DRB Application No.: 10DRB-70085 Project # 1008217
 Project Name: Lands of Salas Properties LLC
 Agent: Wayjohn Surveying Phone No.: 255-2052

RE: Minor Preliminary/Final Plat of Tract A, Lands of Salas Properties LLC, Project No. 1008217

**CITY OF ALBUQUERQUE
PLANNING DEPARTMENT
March 24, 2010
DRB Comments**

**RE: Lot A, Block 1, Zimmerman Addition, and
Tracts 114-B-1 thru 115-E-2, MRGCD Map No. 39**

PLAT OF
**TRACT A, LANDS OF
 SALAS PROPERTIES LLC**

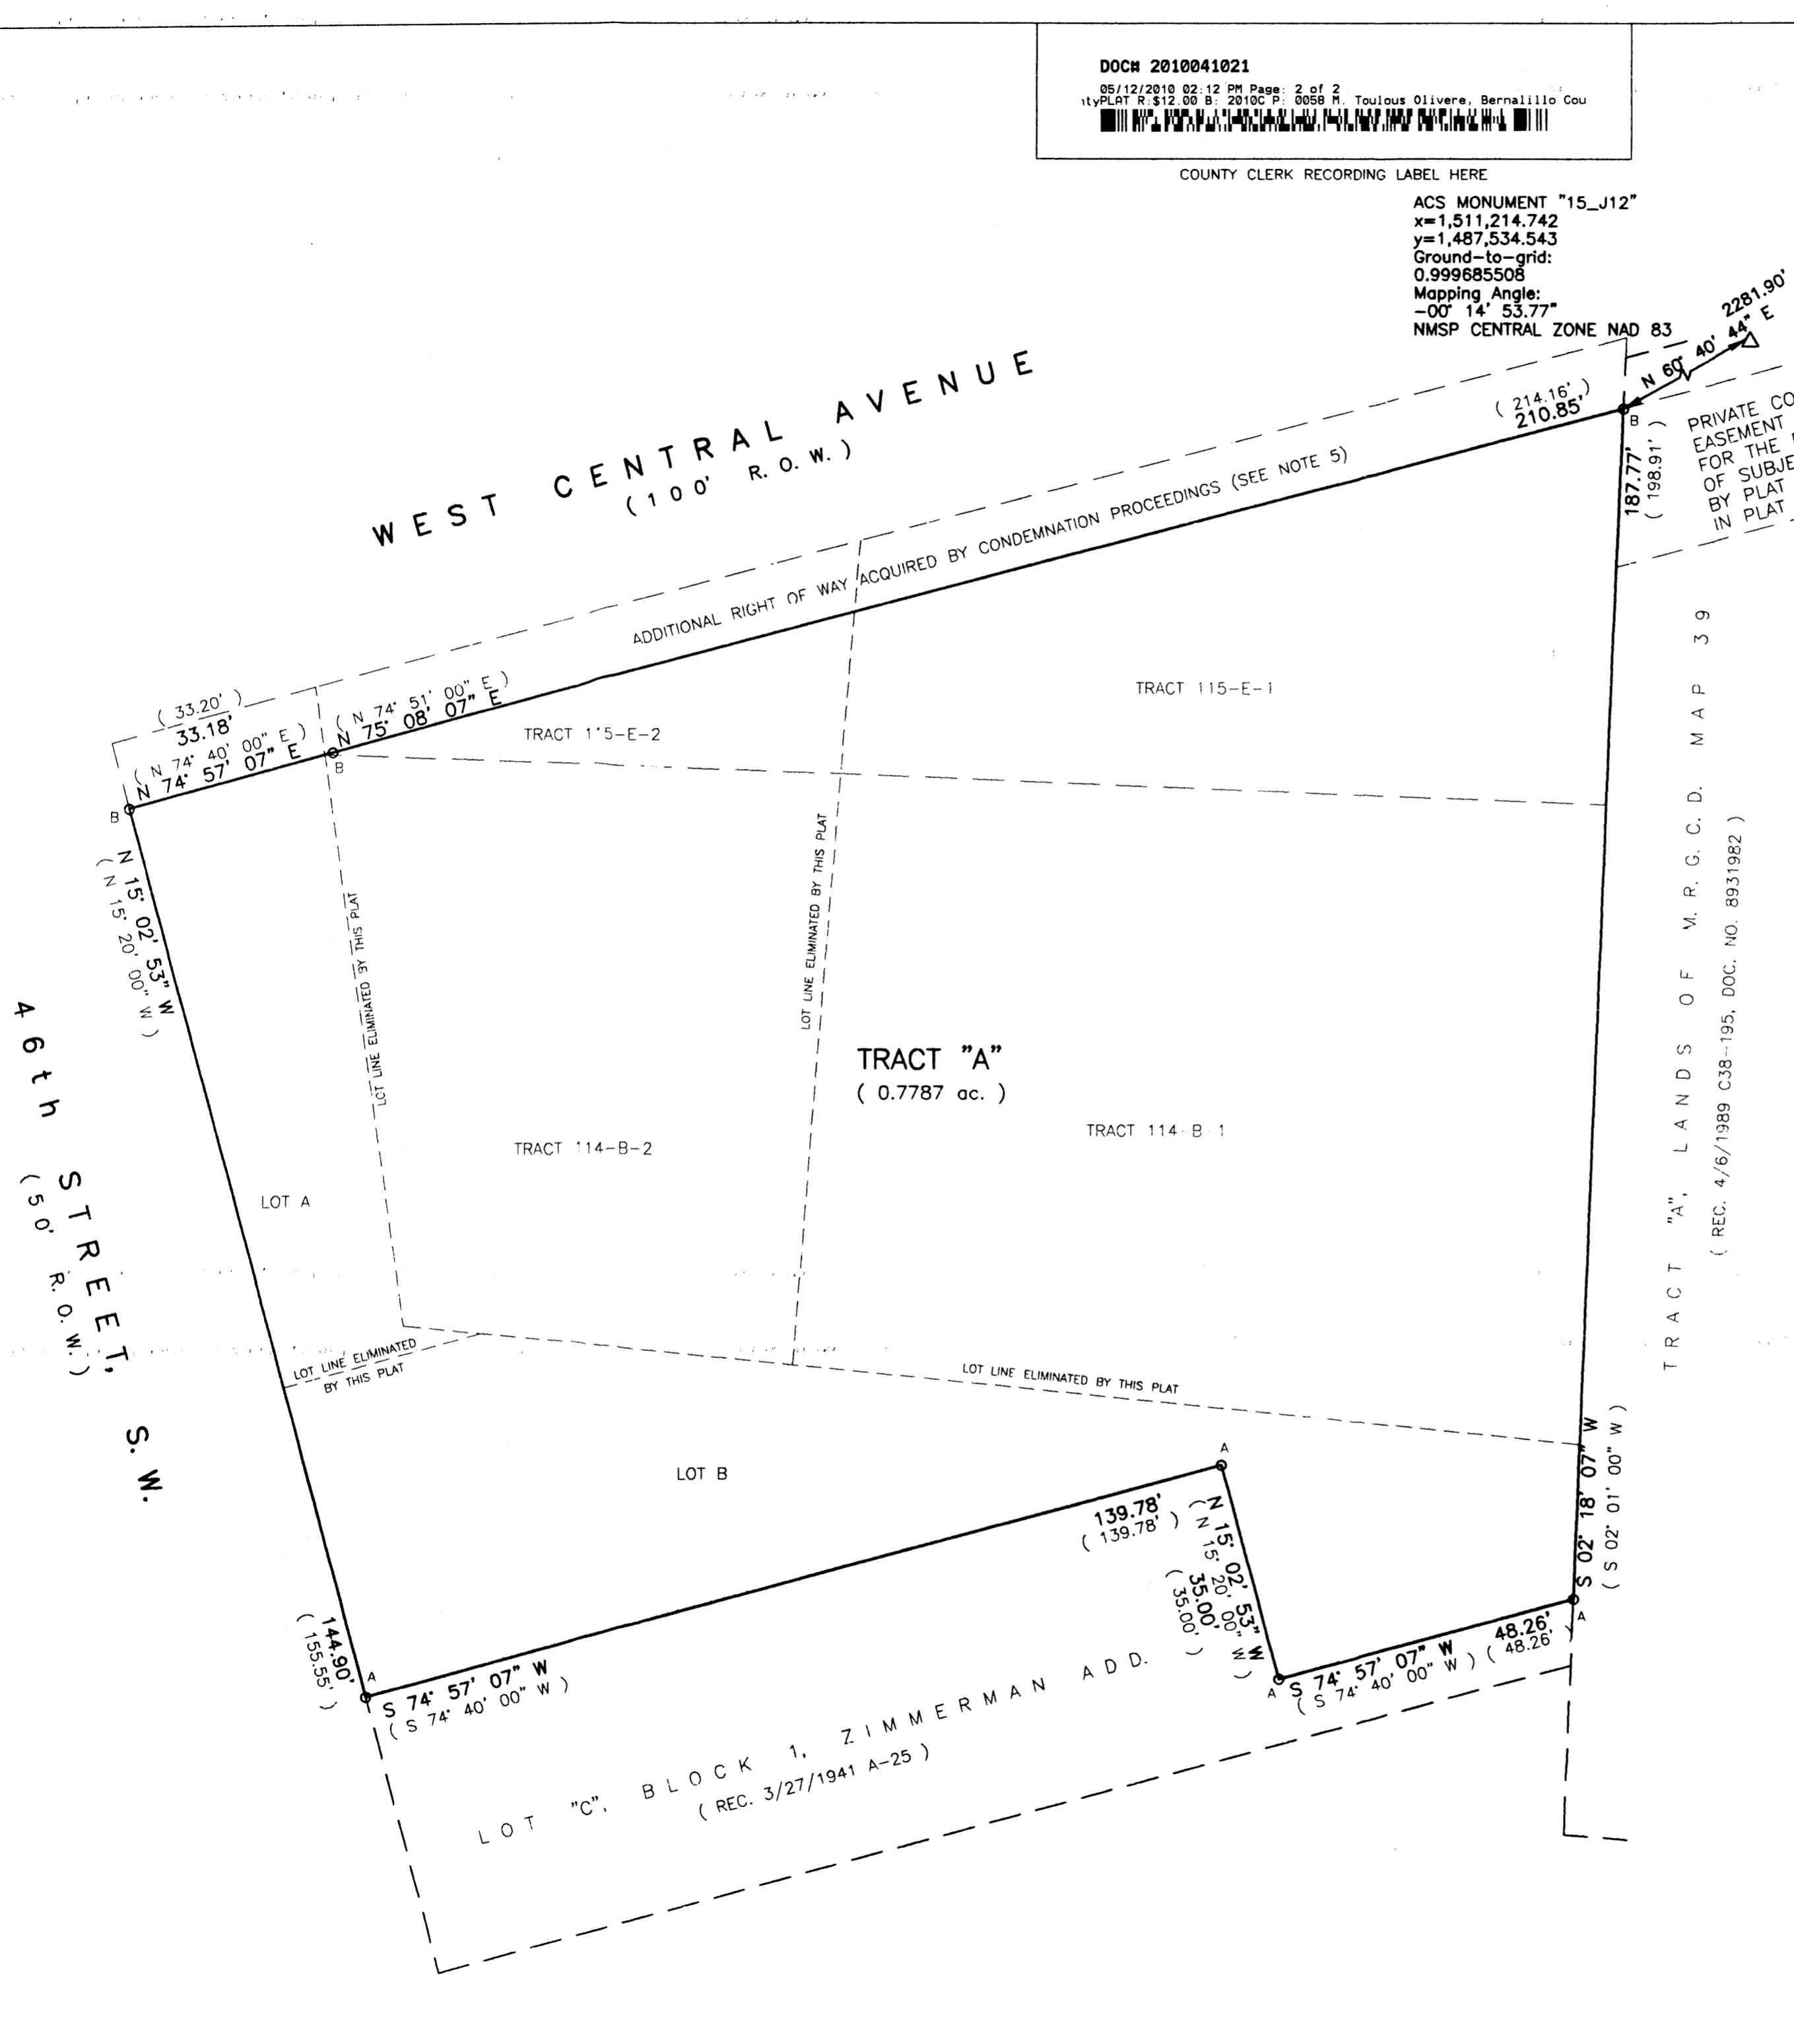
TRANSPORTATION: OK resolve joint access on Central

PLANNING (Last to sign): OK verify well location

EXISTING CONDITIONS

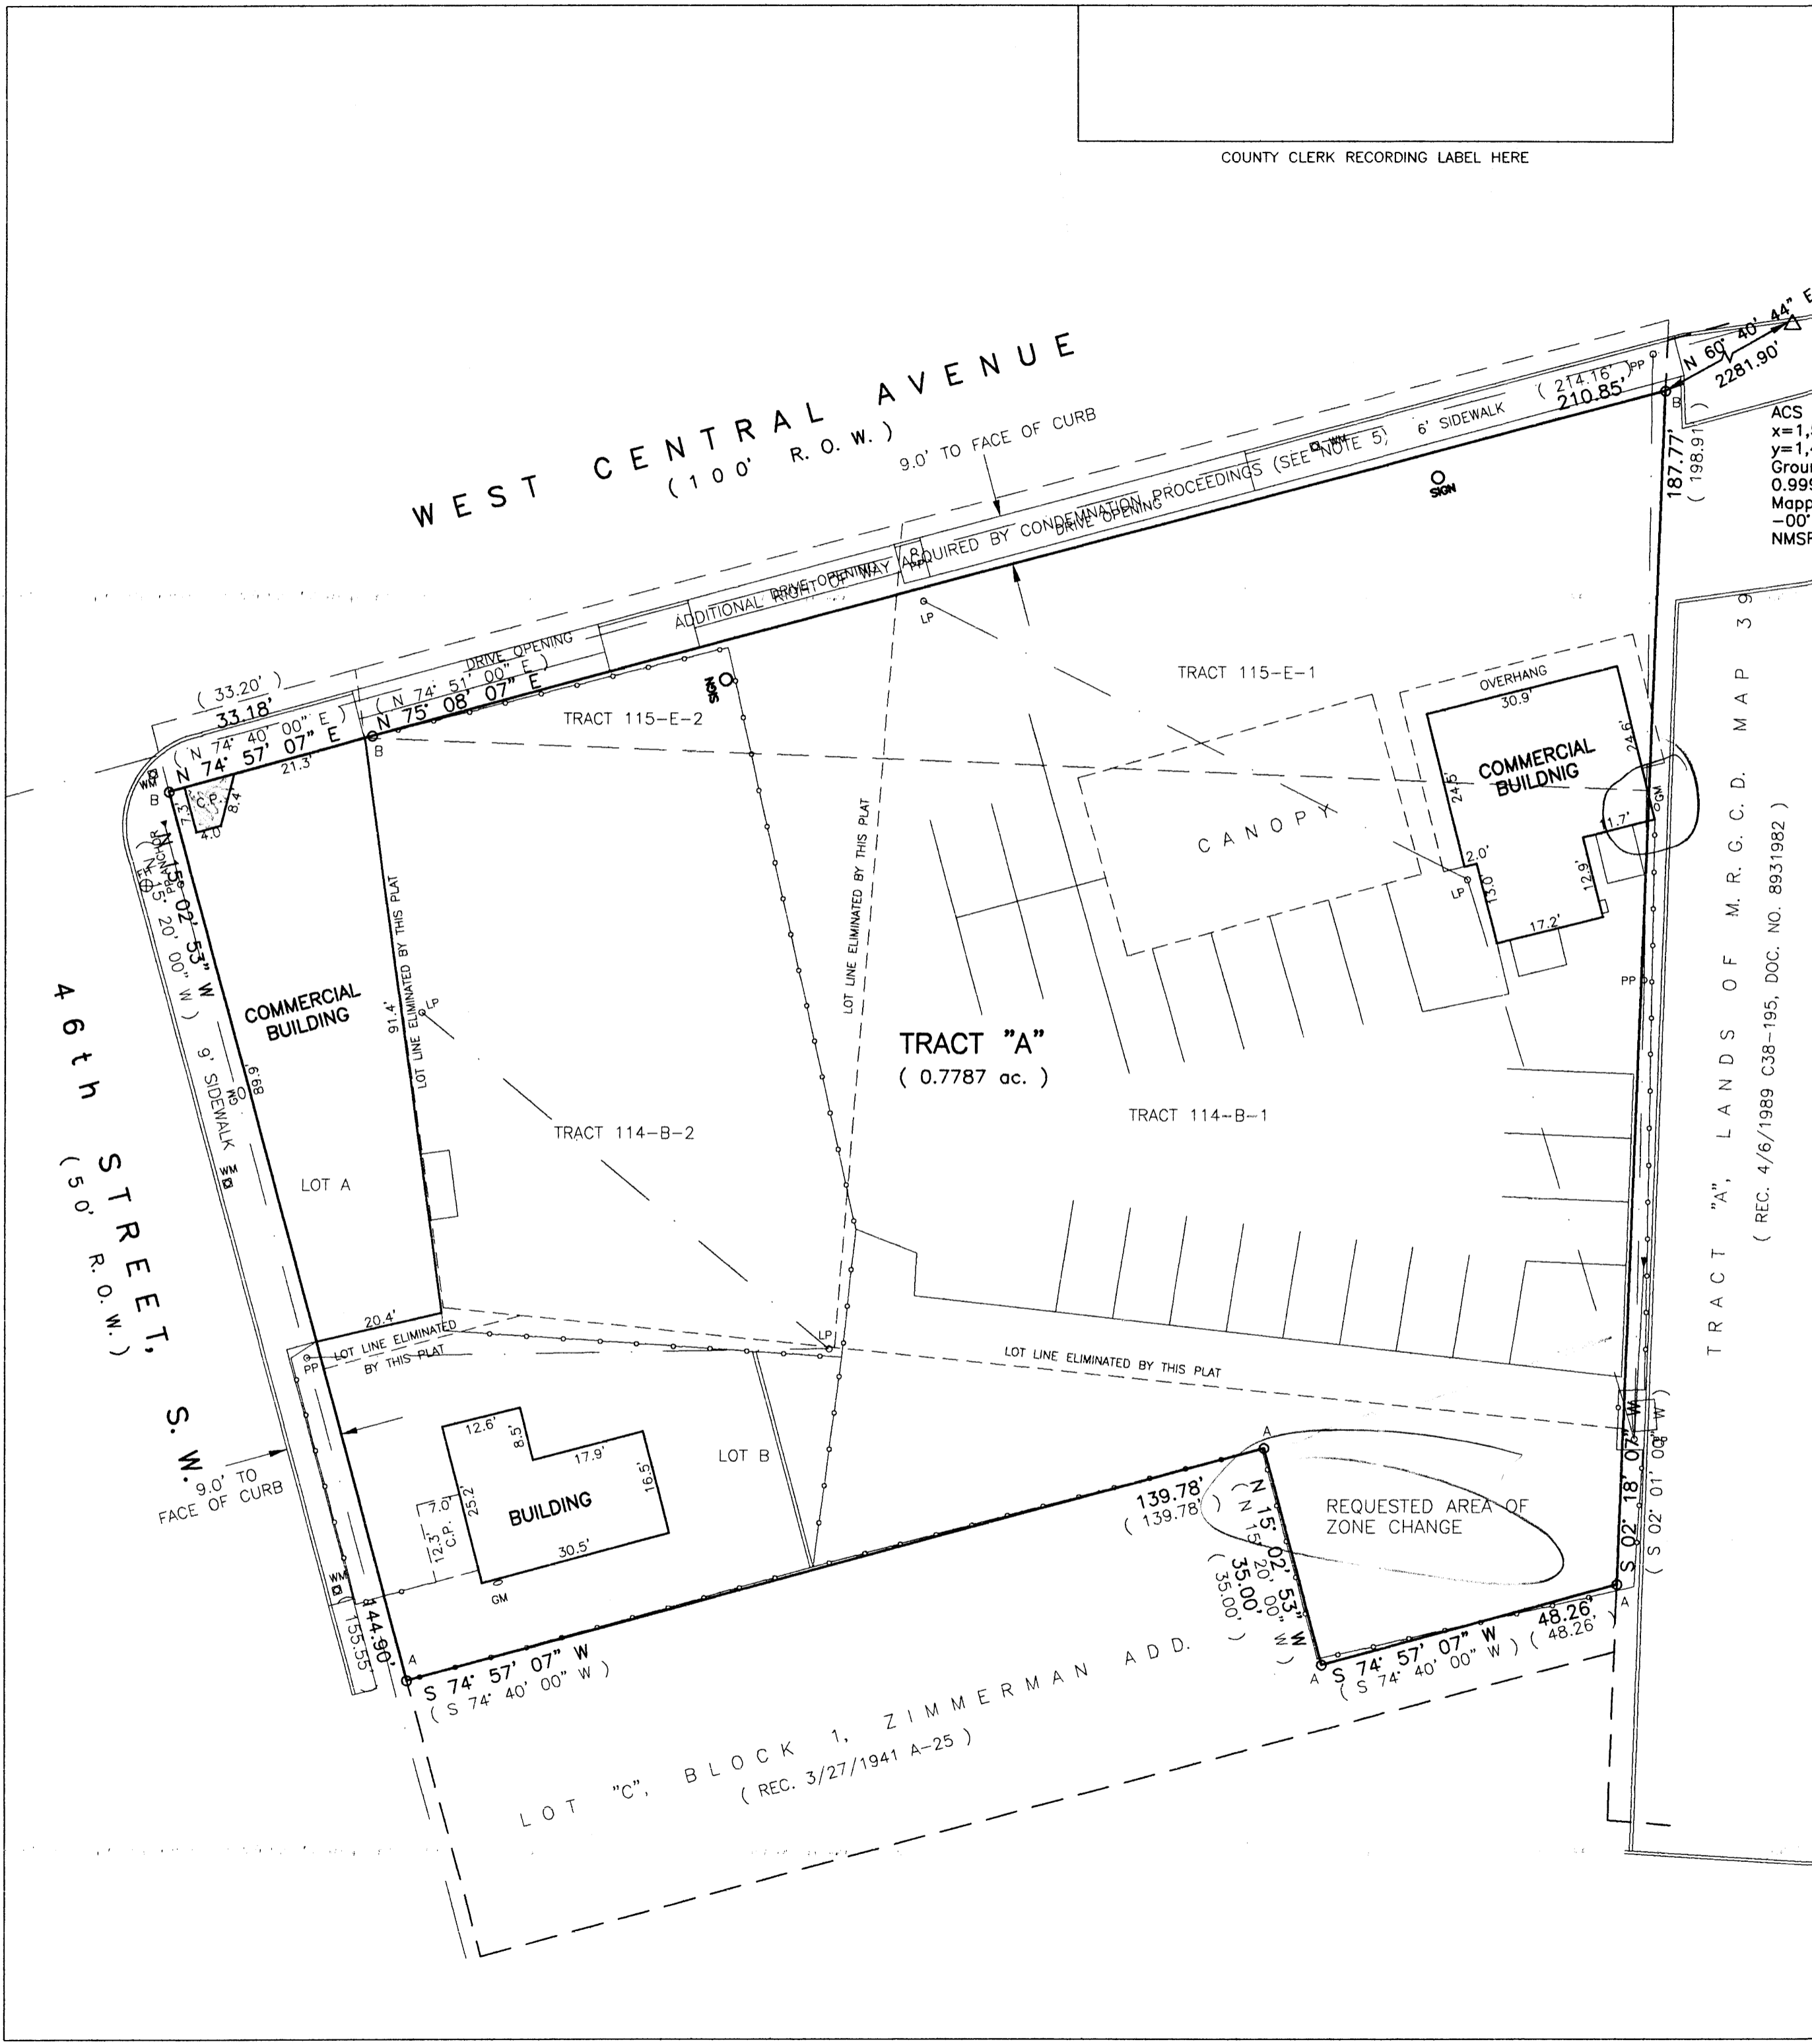
There is an apparent building encroachment on the east property line which needs to be addressed.

This letter is to confirm that the existing structure shown in the existing conditions sketch does not materially encroach onto the adjacent Tract A, MRGCD Map 39. The sketch shows the extents of the eaves overhanging and not the foundation of the structure.
